Subject: R/99/12 Amendments to existing dwelling and new boundary walling - 1 Botany Close, Rustington

Principal Planner

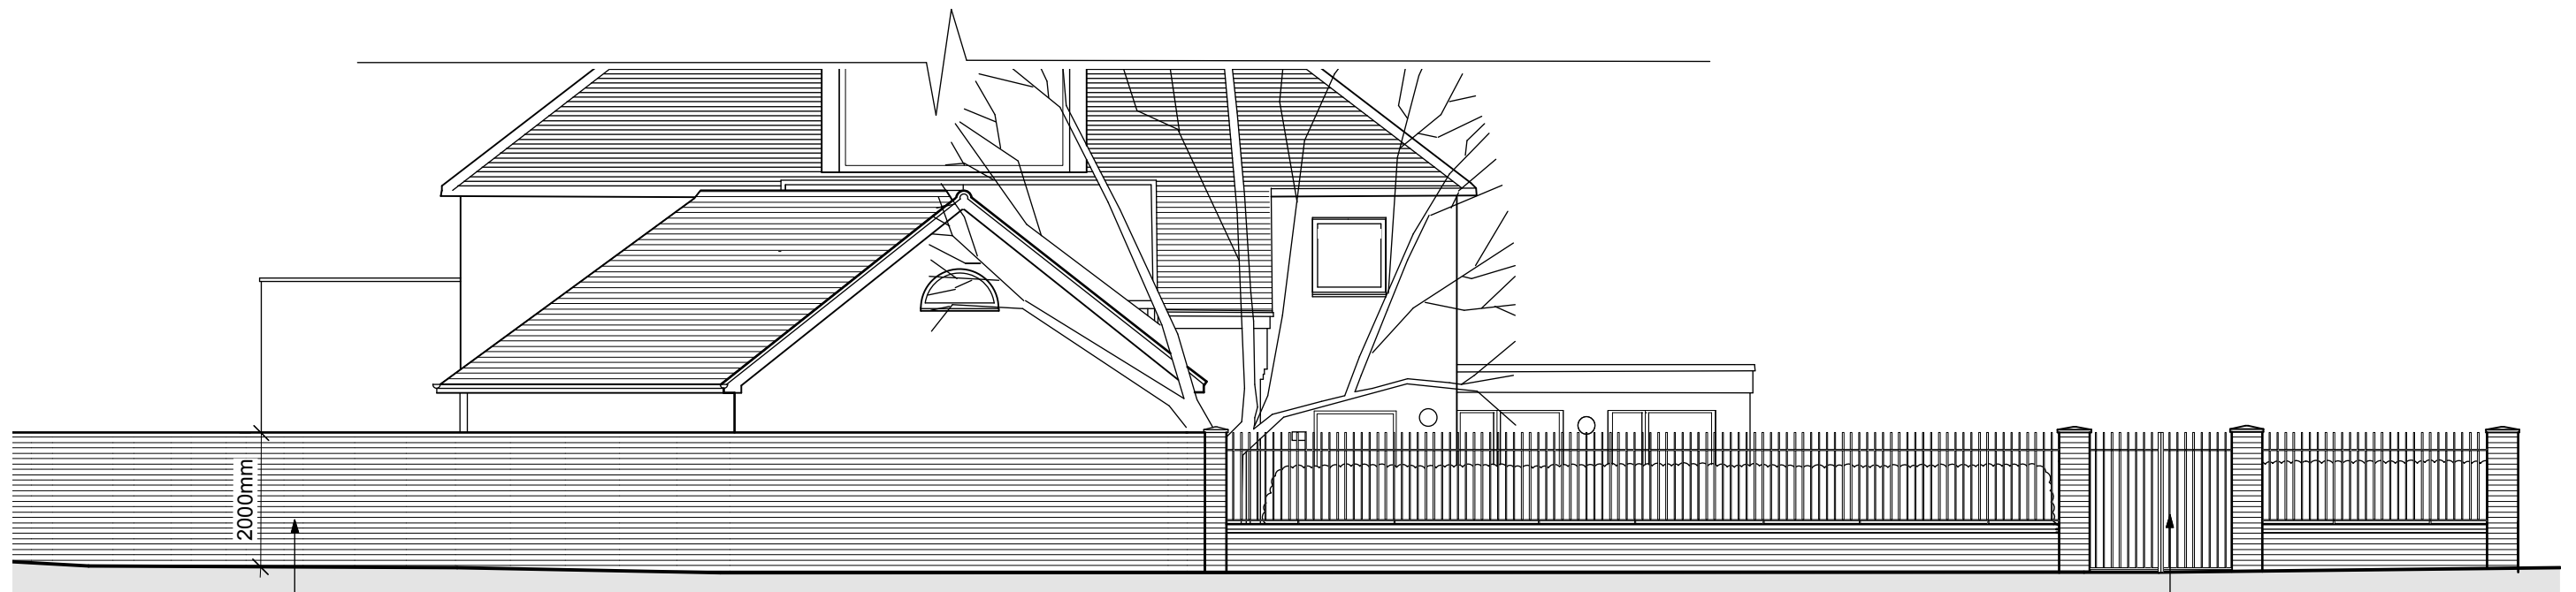
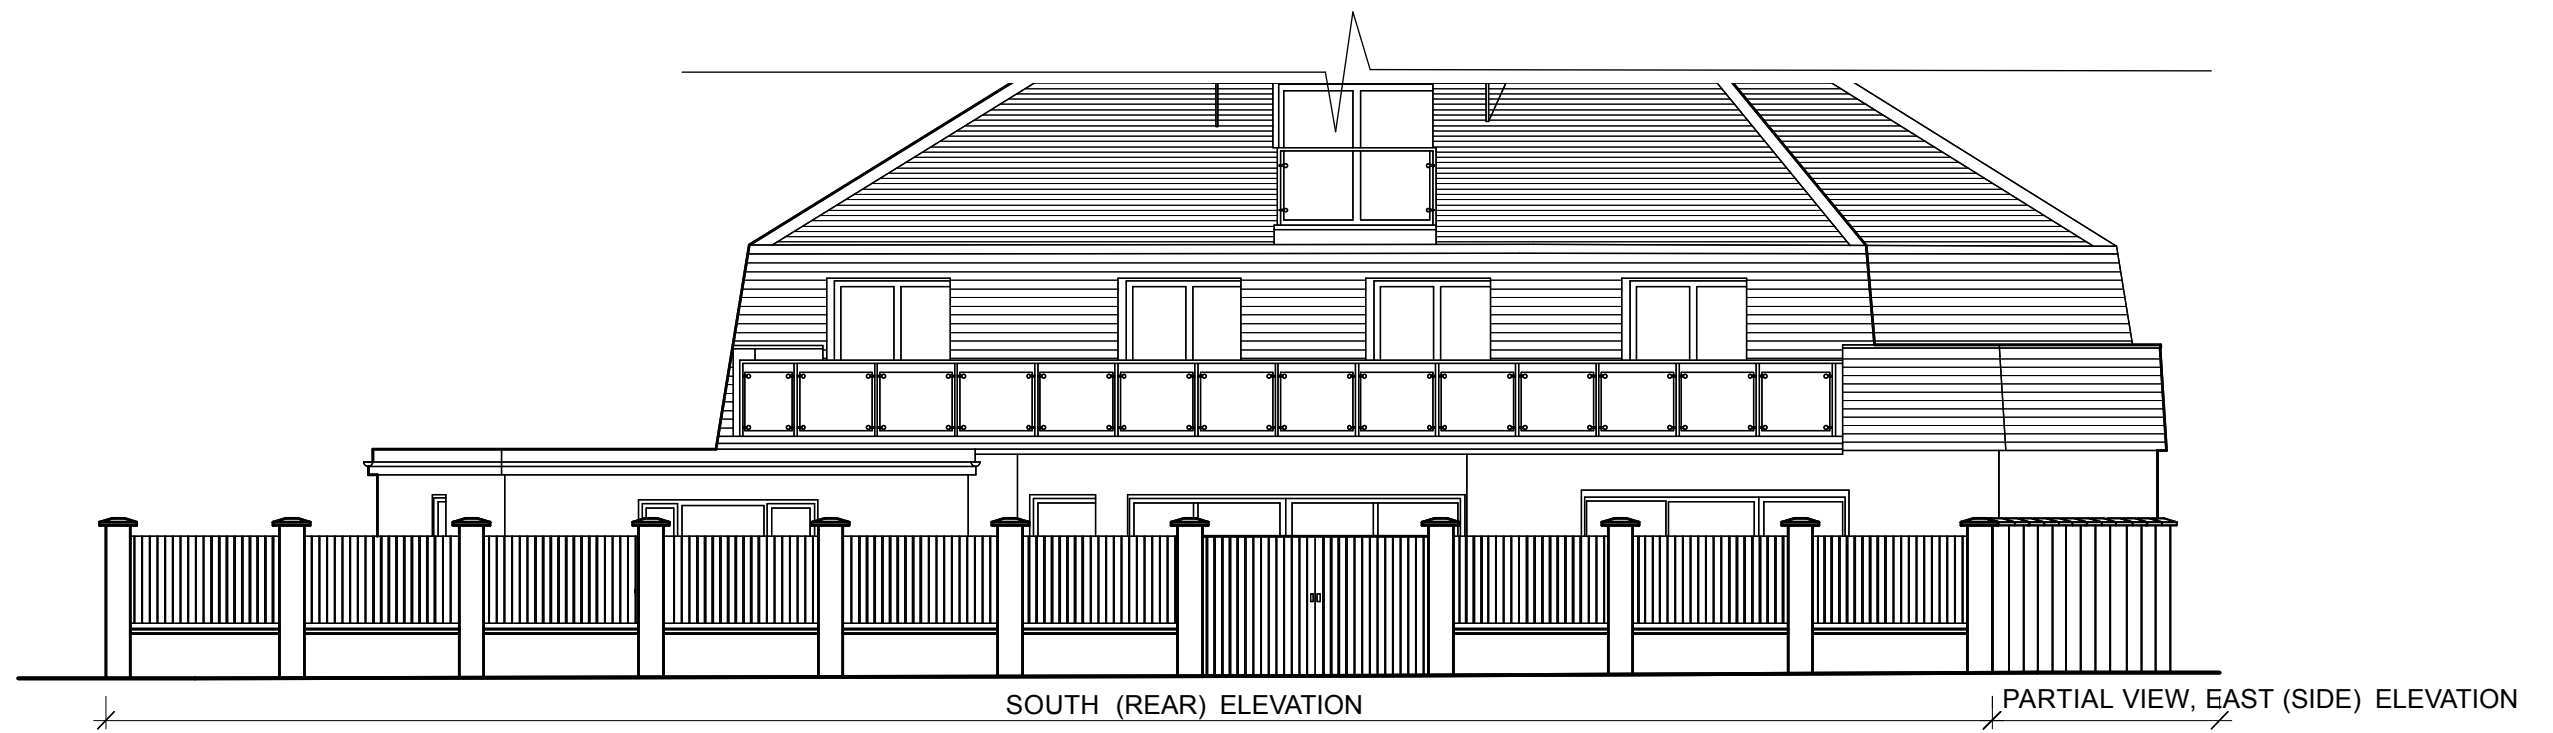
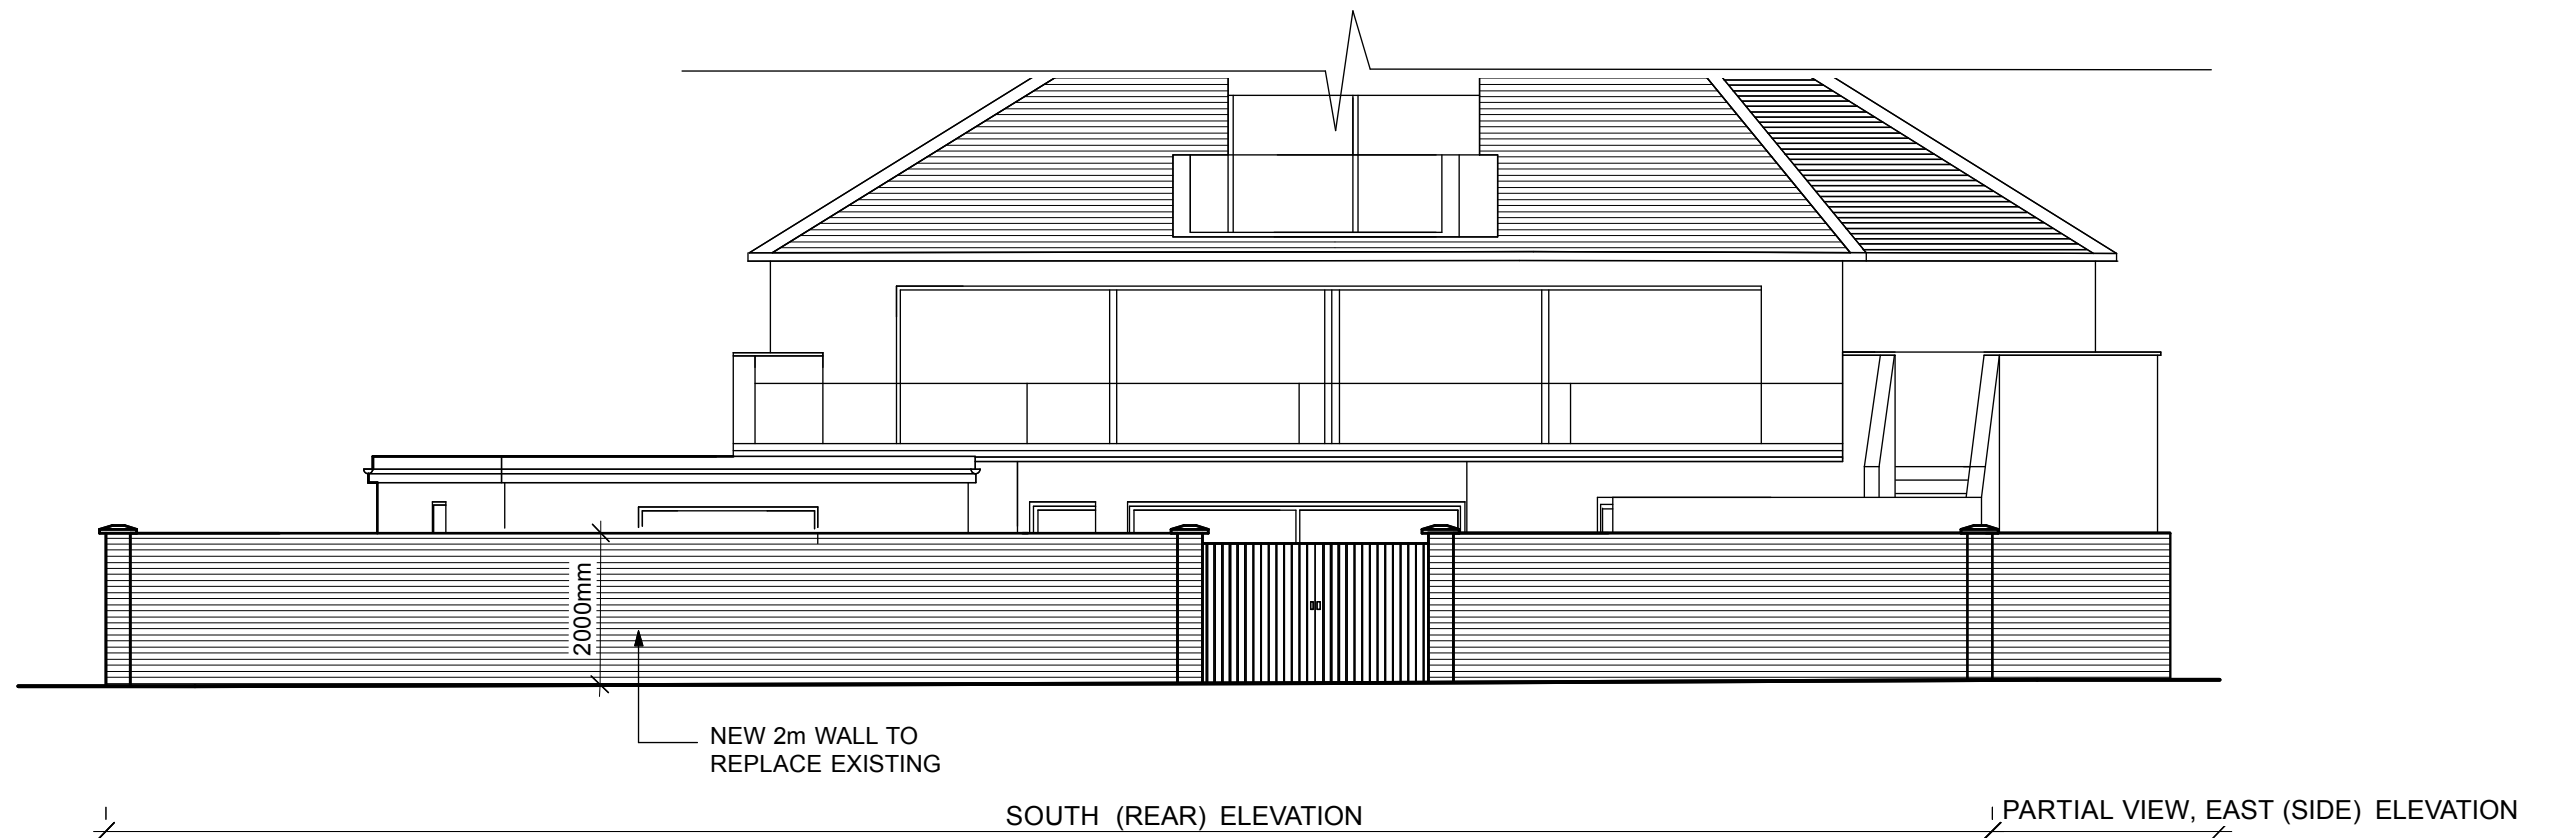
I have noted that the proposed replacement boundary wall adjoins a public footpath to the east and a greensward used by the public to the south I therefore require structural calculations to be submitted as part of the proposal to ensure the walls would be structurally sound. I am unable to condition this requirement.
